19 February 2020

**RE: Revised Submission on the proposed Walla Walla Solar Farm (300MW)
Lots 16, 17, 20, 21, 87, 88, 89, 108, 109 118 on DP753735, Lot 3 on DP253113, Lot 1 on DP1069452,
Lot A on DP376389, and Lot 1 on DP933189**

Thank you for you for the opportunity to review and provide comment on the Walla Walla Solar Farm Environmental Impact Statement. This revised submission supersedes previous issued on 29 November 2019 during the Public Exhibition Period for this State Significant Development.

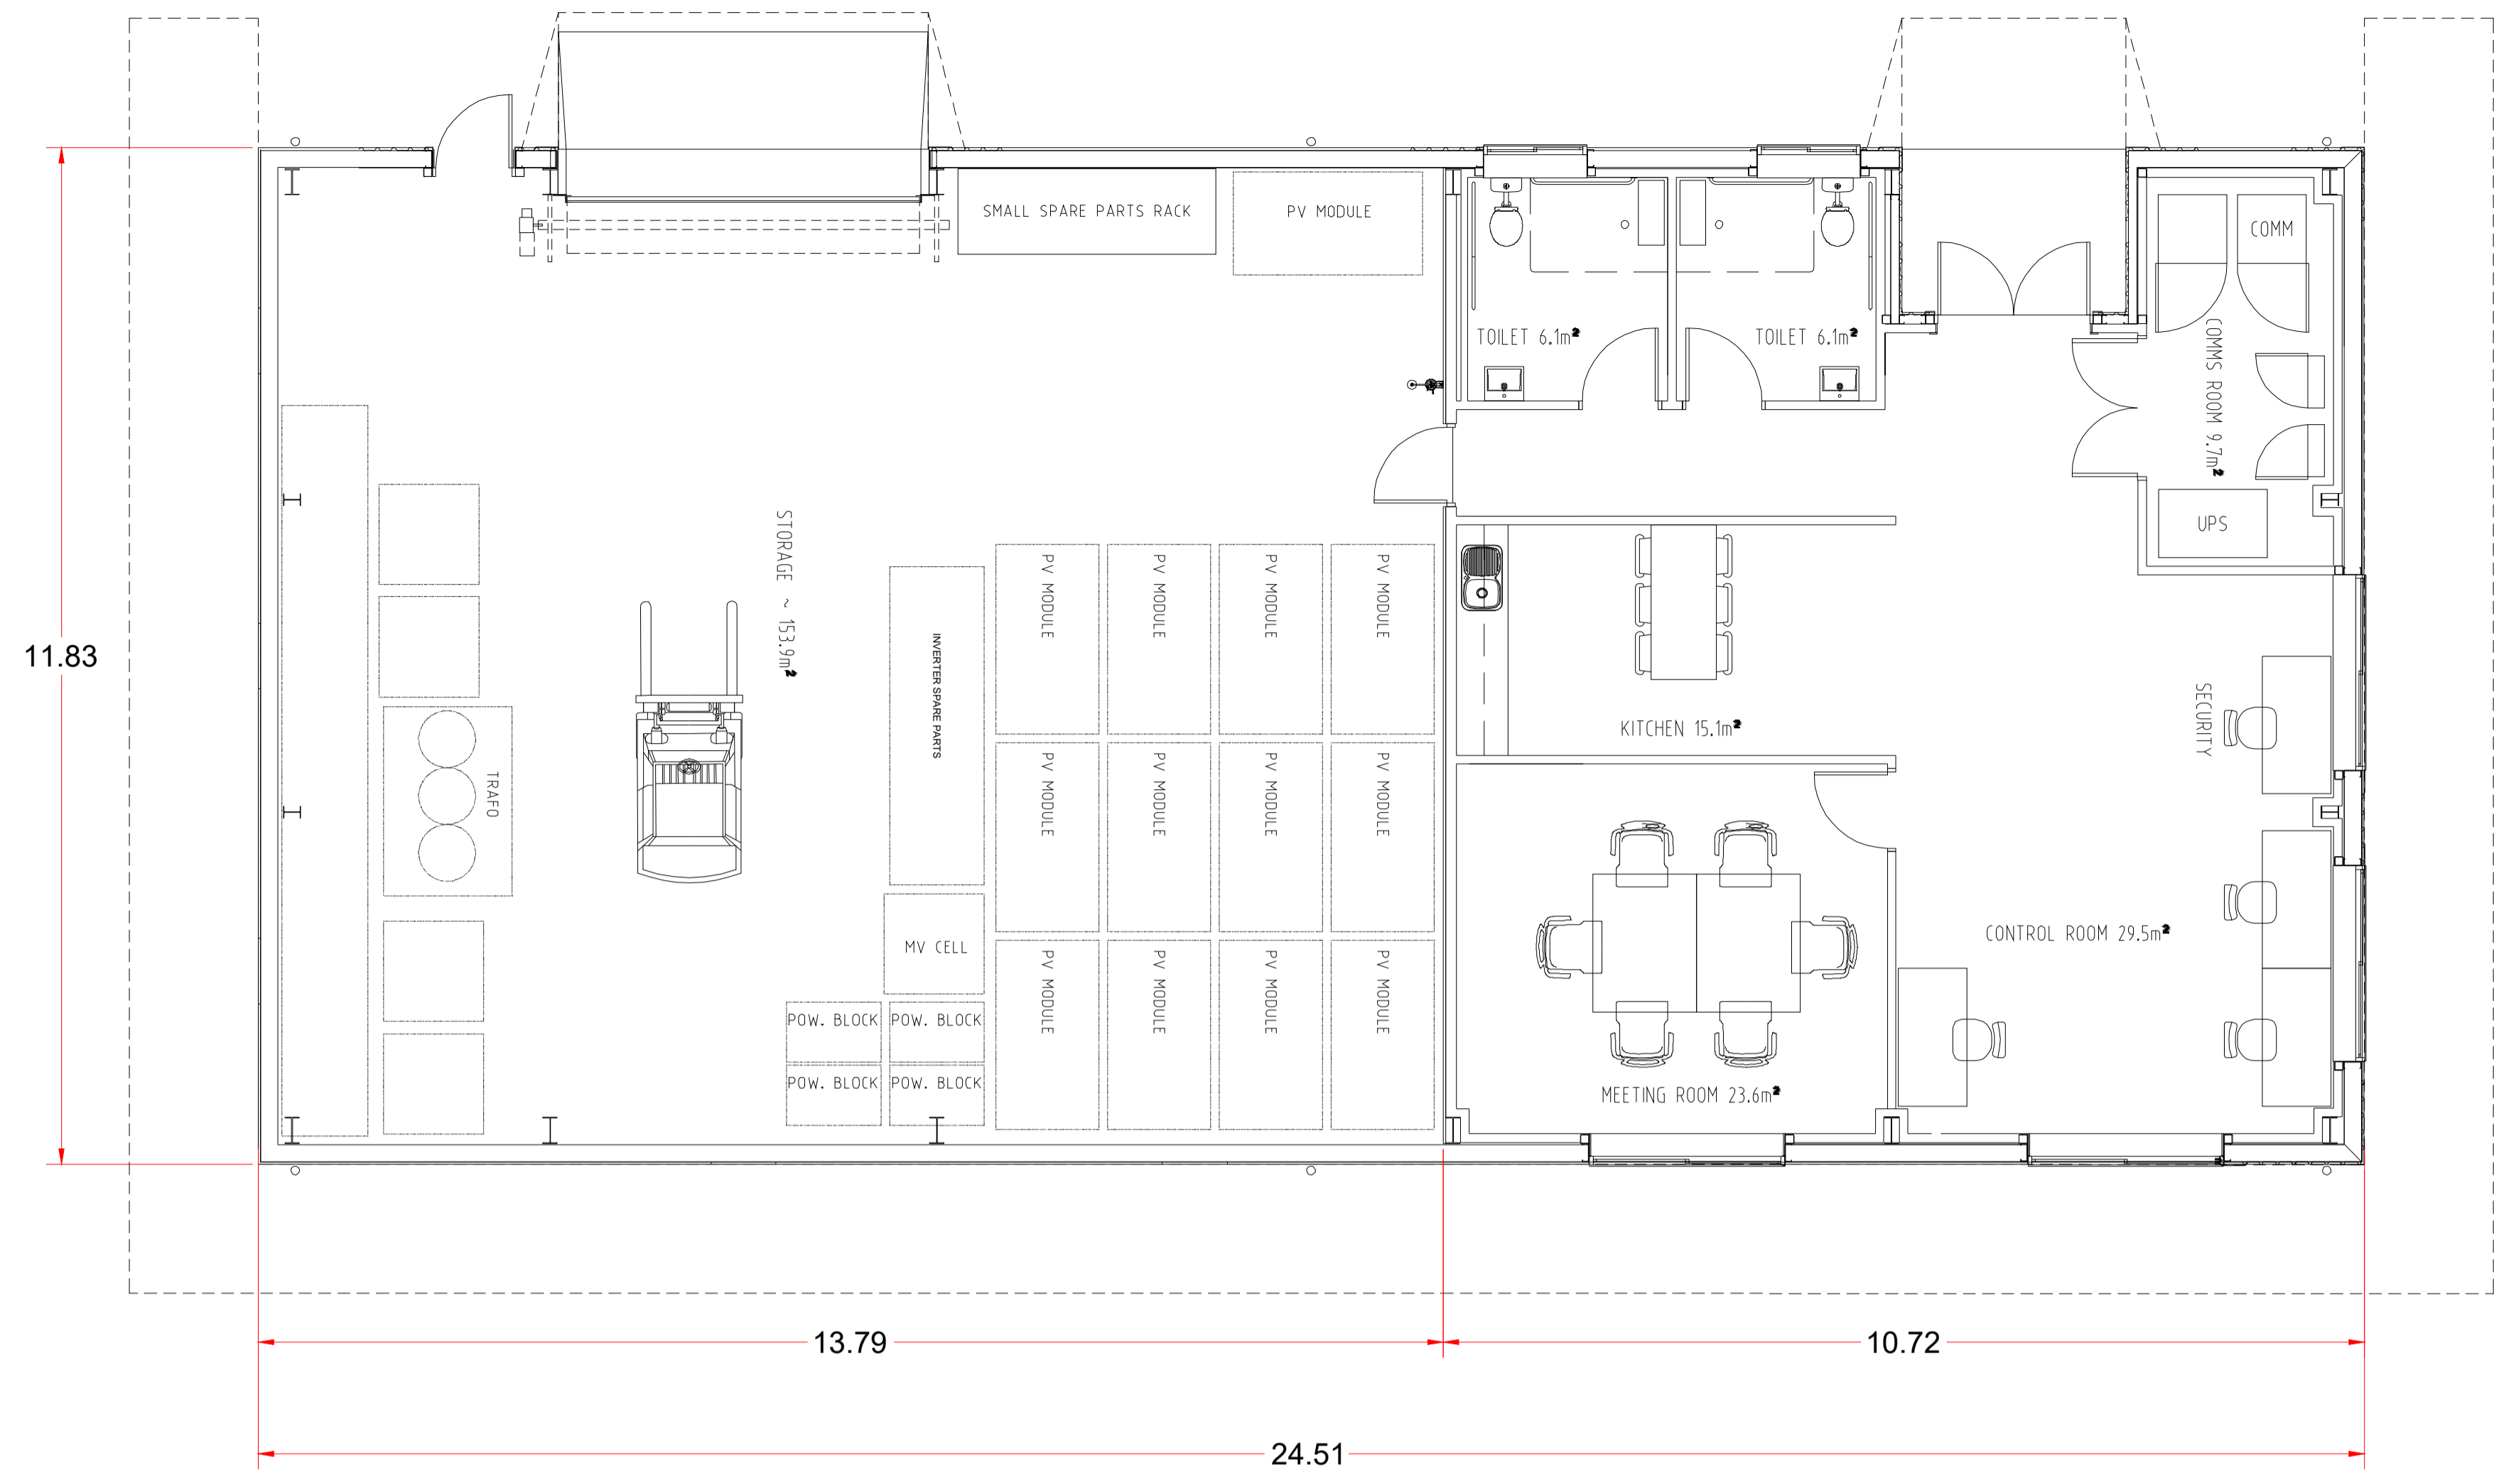
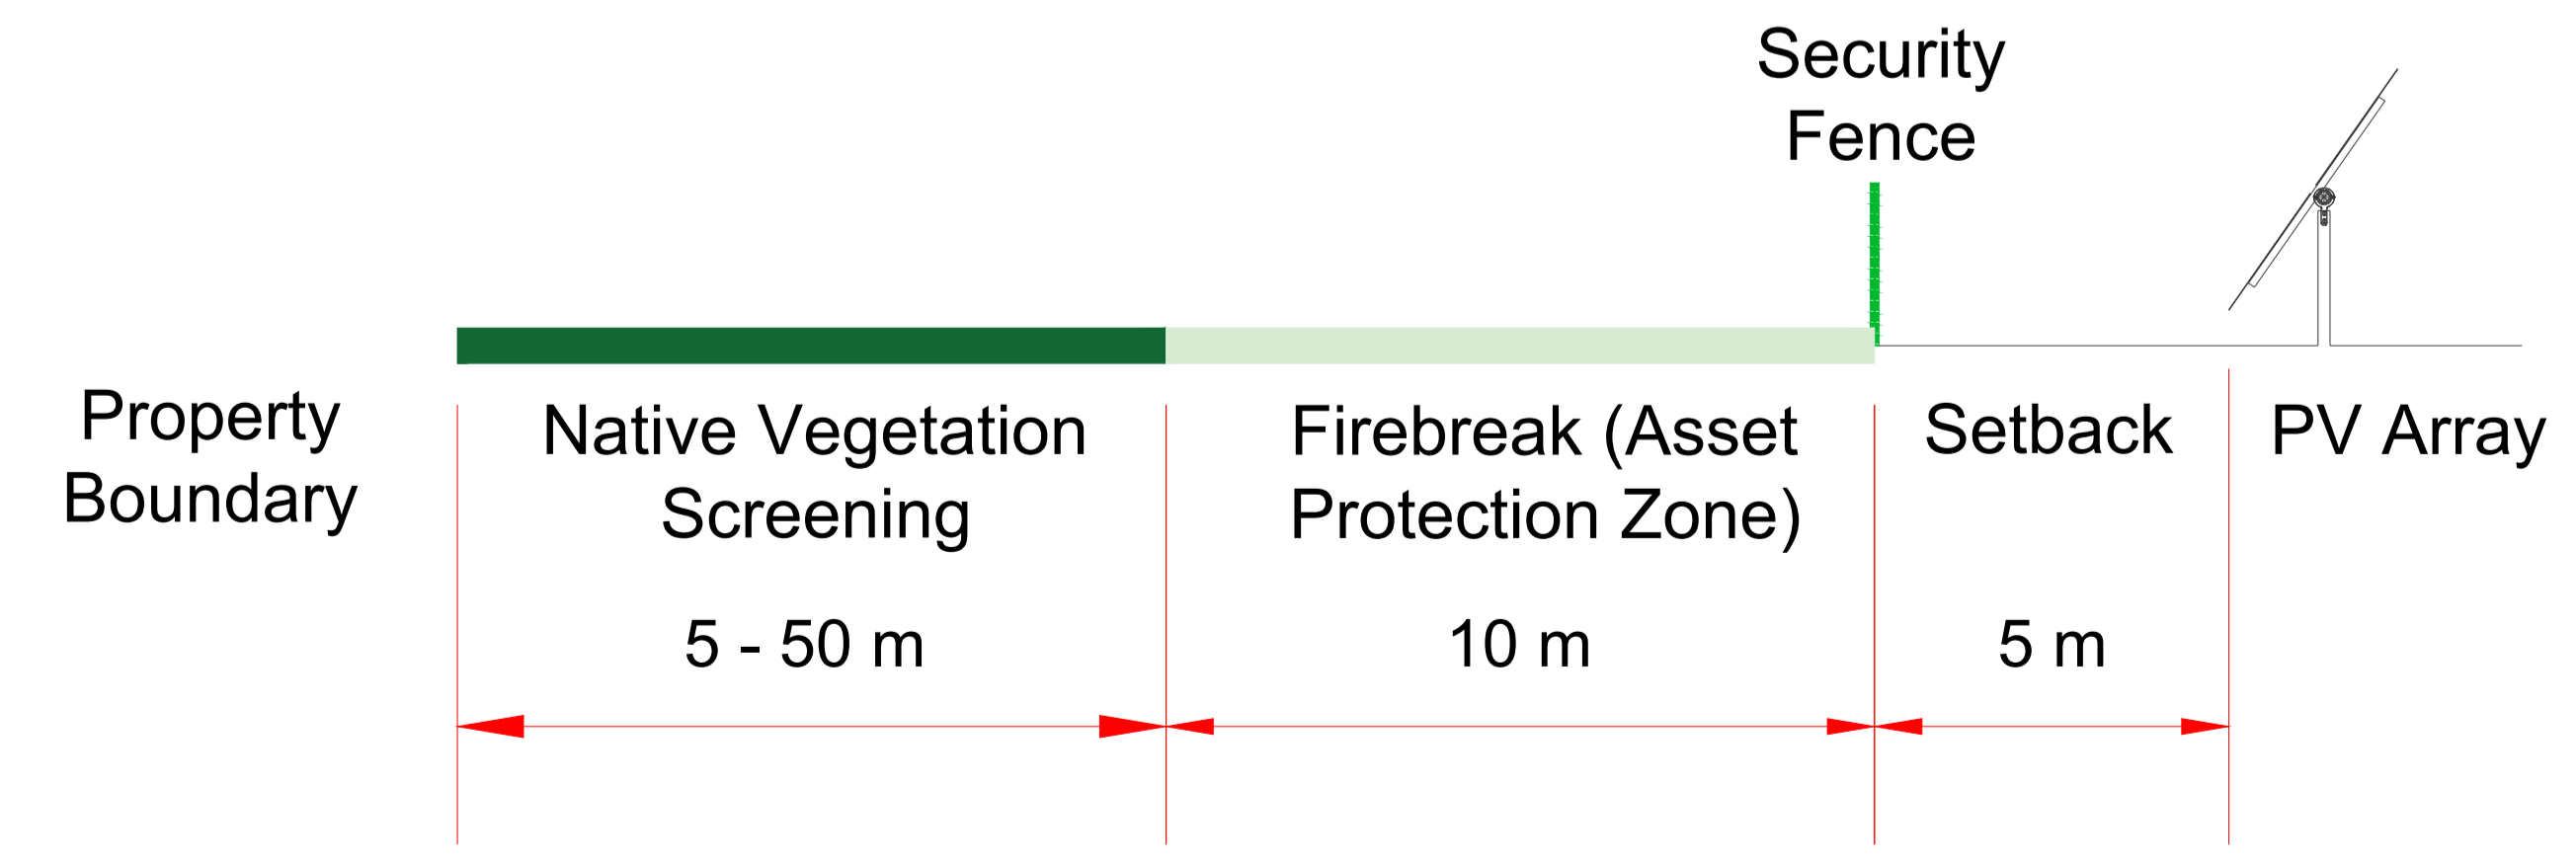
The Walla Walla Solar Farm General Layout Plan (dated 190822, Revision 00) outlines APA's 24-wide pipeline easement. The easement is clear of the siting of solar panels, although panels are shown up to the boundary of the easement. However, APA's infrastructure is not accurately labelled as a "high pressure gas transmission pipeline", nor is there a specific consideration of the HPGTP within the Statement of Environmental Effects. All plans associated with this development must include the gas pipeline easement so that construction workers, and associated contractors are aware of the gas pipeline and its location.

The proposal plan also indicates landscaping is to be located within the HPGTP easement. APA will not accept all forms of landscaping on the easement as it has the potential to impact on the pipeline's integrity and inhibit the ability for APA to manage and maintain the HPGTP easement. Any landscaping considered as part of this proposal on the easement is required to be submitted to APA for consideration.

Prior to the development commencing, landscape plans depicting any planned landscaping, including the planting of vegetation, species details, surface treatments, furniture, structures or improvements within three metres of the pipeline must be submitted to and approved by APA, in addition to any approval required by the assessment manager. A three metre minimum clearance between the pipeline and any vegetation with a mature height greater than 0.5 metres must be maintained.

All plans which include the area of the gas pipeline easement must have the easement clearly identified with hatching on the full width of the easement. The easement must also be clearly labelled as *'high pressure gas pipeline easement – no works to occur without the prior authorisation of the pipeline operator'*.
